File Name: ISH6 - 26 June 2023_Part 3.mp3

**Figure 10.1iv**  
**Cromwell Road/New Bridge Lane Signal Scheme - General arrangement**

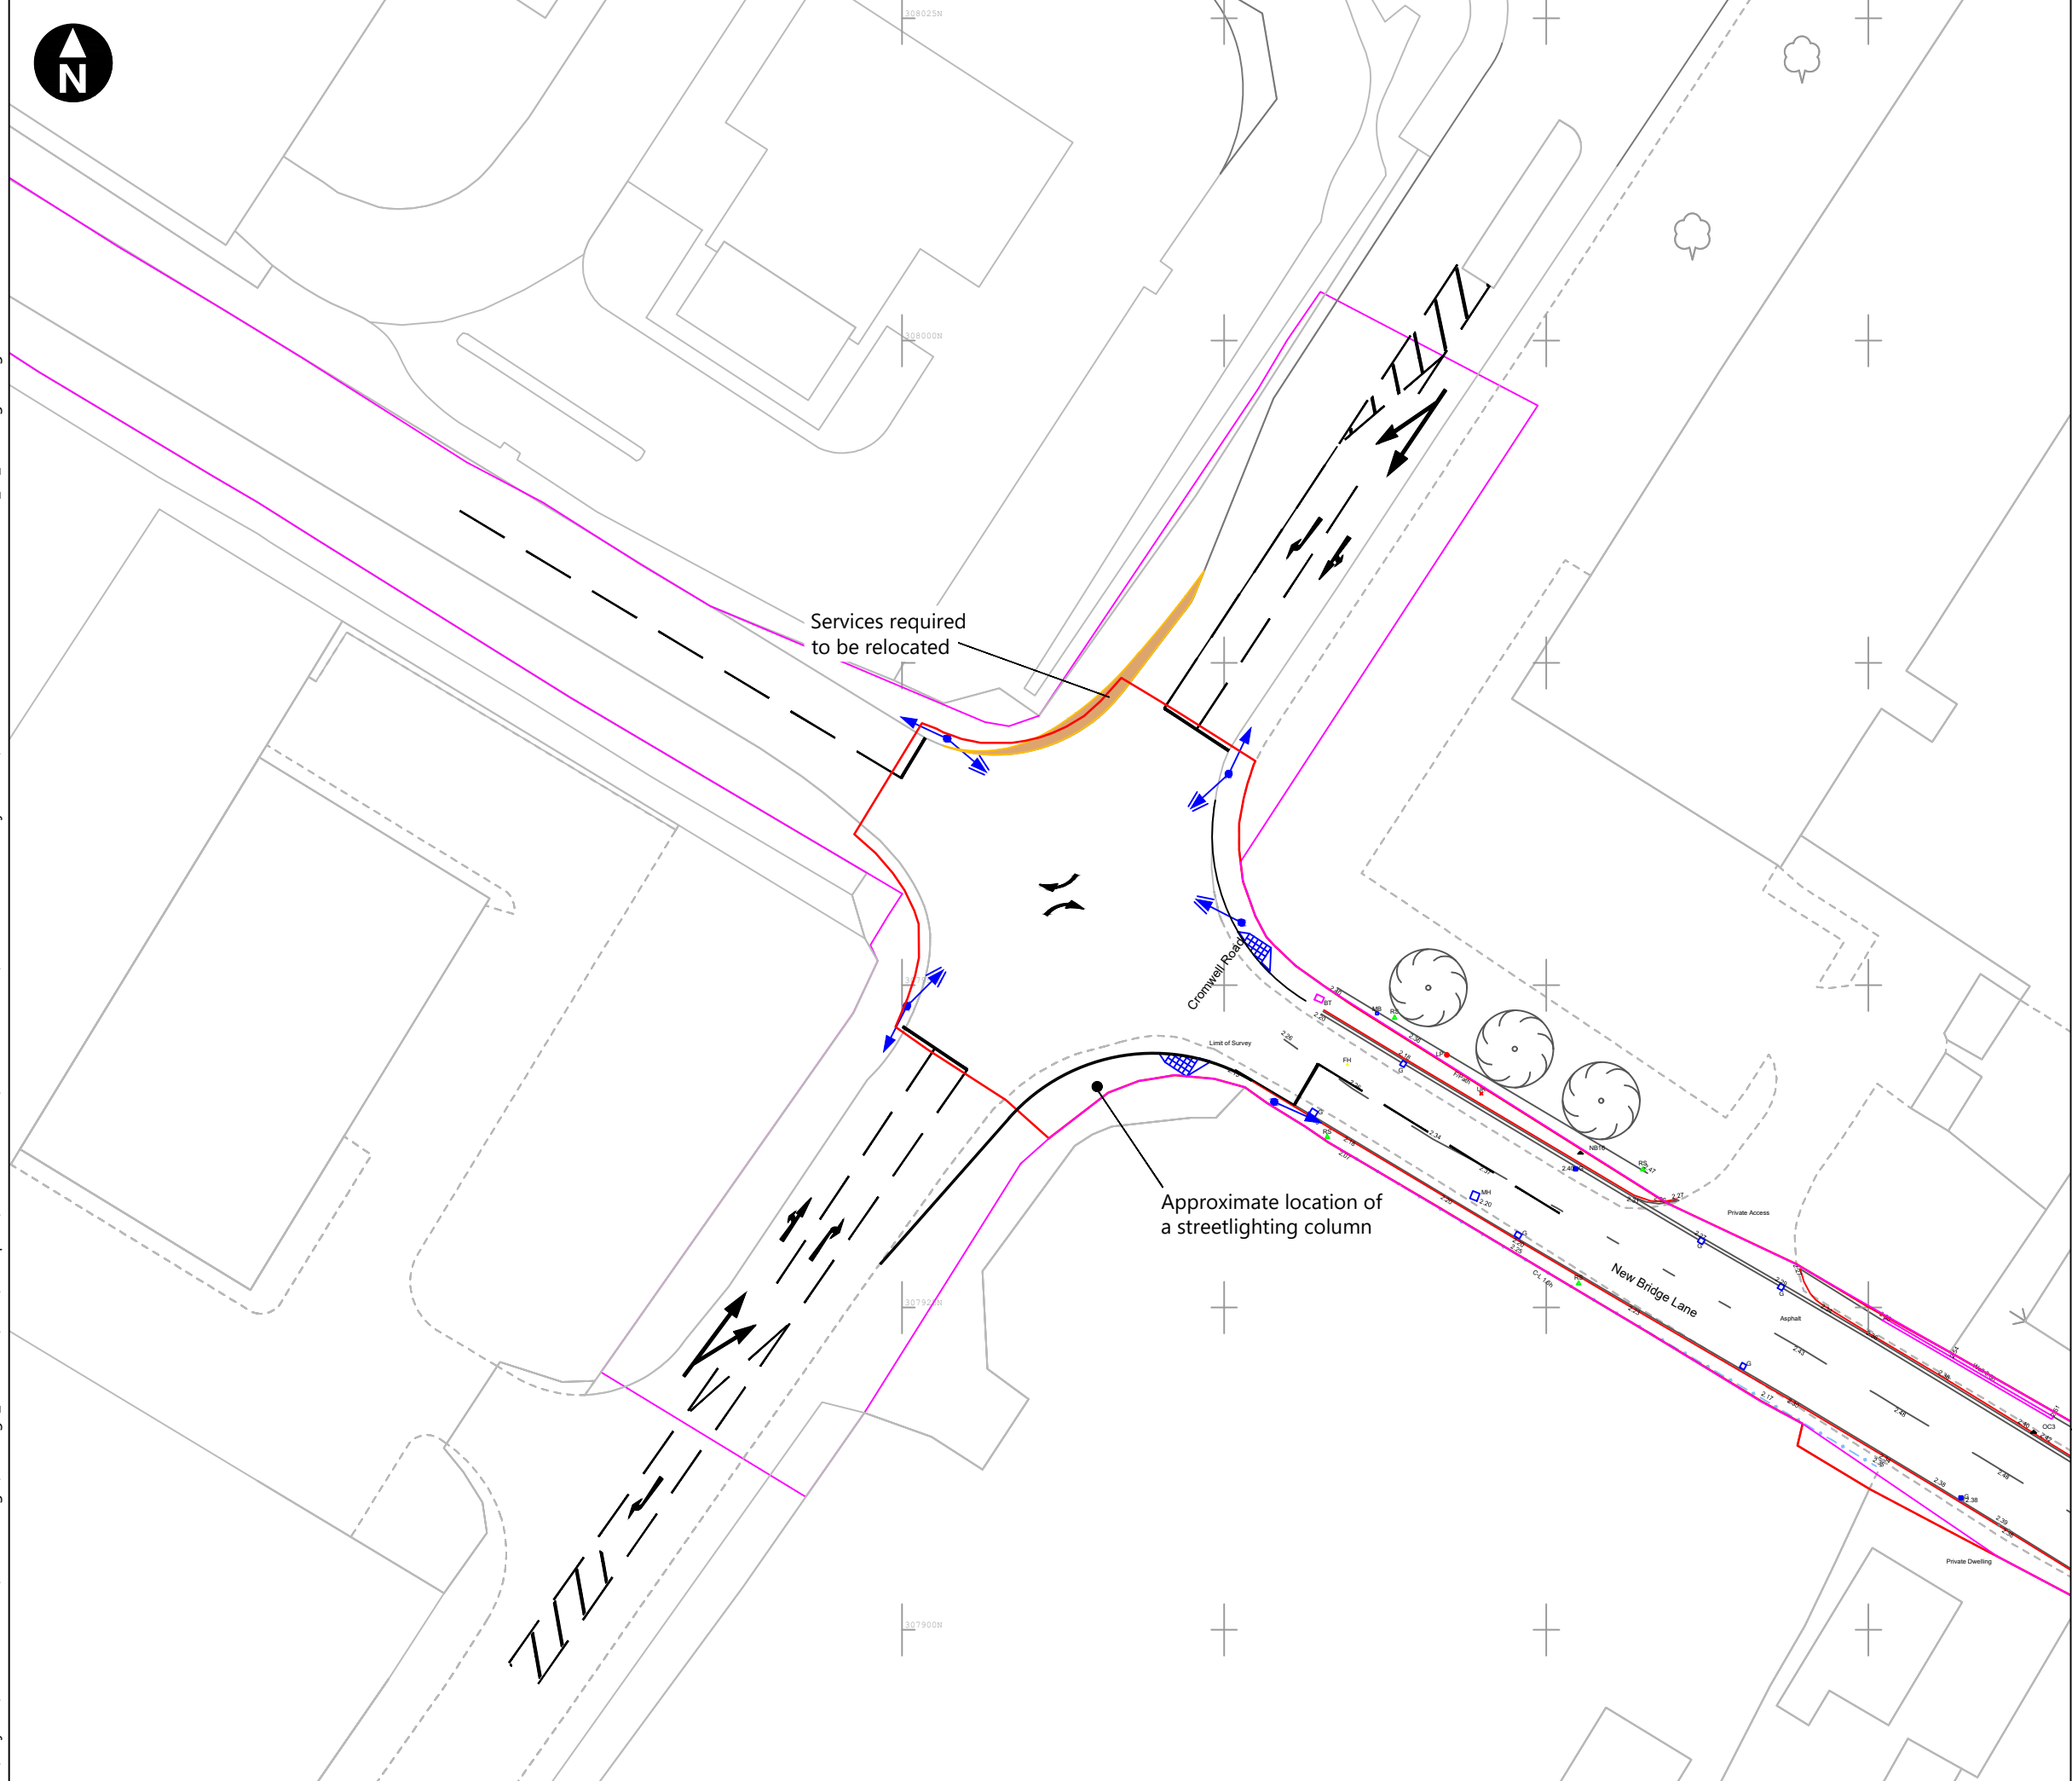
Good afternoon, sir. My name is Jeff Tuttle of the Transport Assessment and Smart Journeys Manager at Cambridgeshire Council. Um, so we've been reviewing the, um, the transport assessment, the revised junction design submitted along with my colleagues in the, the signals team. Um, and whilst we are broadly happy with the flows they've used, some of the Tesco's flows are in assumption, but we're broadly happy with the assumptions they made. We do have some concerns about the signal phasing, um, because it still does appear that it allows the right turn.

Traffic from the south to move on to Newbridge Lane without stopping the north. The southbound traffic from the from the north, sorry, the northbound traffic to go through. Without stopping the southbound traffic. And our safety consideration was that traffic would need to be stopped in all settings to allow the vehicles to turn right. Yet the phasing diagram submitted in the assessment addendum and also the modeling files looked at would appear to show that actually the northbound traffic isn't stopped in all settings.

Very much. Thank you. Okay. Um, so when we. I'll go through it again. Broadly speaking, we looked at the flows and we broadly happy with the flows that they've used, albeit that there's some assumptions in there. Um, but we don't feel that that's, um, you know, enough for us to say, well it's, you know, broadly speaking it's not correct. But what we do have is a concern over the phasing of the traffic signals. Now the safety issue we highlighted was that we wanted all traffic coming from the south.

That's the a47. When it turns right into Newbridge Lane, we want all that southbound. So traffic coming out of Wisbech traffic stopped so that the traffic can turn right without any conflict. And at the moment it seems that the staging diagram doesn't do that. So there's still potential for north southbound traffic coming across the the right turning traffic to actually do so and we need the staging completely separate so that the southbound from Wisbech traffic is stopped to allow the vehicles turning right into Newbridge Lane.

Sorry, Sir Richard Ling. Traffic Signals and systems manager at Cambridgeshire County Council. Um, yeah. The with the new layout, they've got separate two lanes, as Jeremy Tuttle has just said, into the development, which has got an arrow can an arrow can go on to the island that's been provided so there's no reason the staging can't be changed simply and then remodelled to show that safely the manoeuvre that we've just spoken about.

Great. Thank you. So these are some points that we spoke to the we contacted the applicant about last week. They probably haven't had a chance to look at it yet. Don't know. But firstly, in terms of the land space that is included in the application for an amendment. Um, the additional land identified by the applicant on the carriageways of Newbridge Lane and Cromwell Road doesn't appear to achieve a sufficient distance back from where the proposed stop lines would be installed at the revised junction layout. So a minimum distance of think 50m is required to ensure that appropriate road surfaces and sensors can be installed at the correct locations at the junction.

Um, additionally, on the western side of the crossroads, on land that borders the Merc's car garage. Um, the boundary has been expanded slightly. Um, but there does appear to be limited space in one area, and whether extra space is needed here would depend entirely on the amount that the road would need to be expanded, what infrastructure is required to be installed, and the visibility requirements that may come into play as part of the revised design. Um, so that's the concern in respect of the crossroads of Newbridge Lane and Cromwell Road.
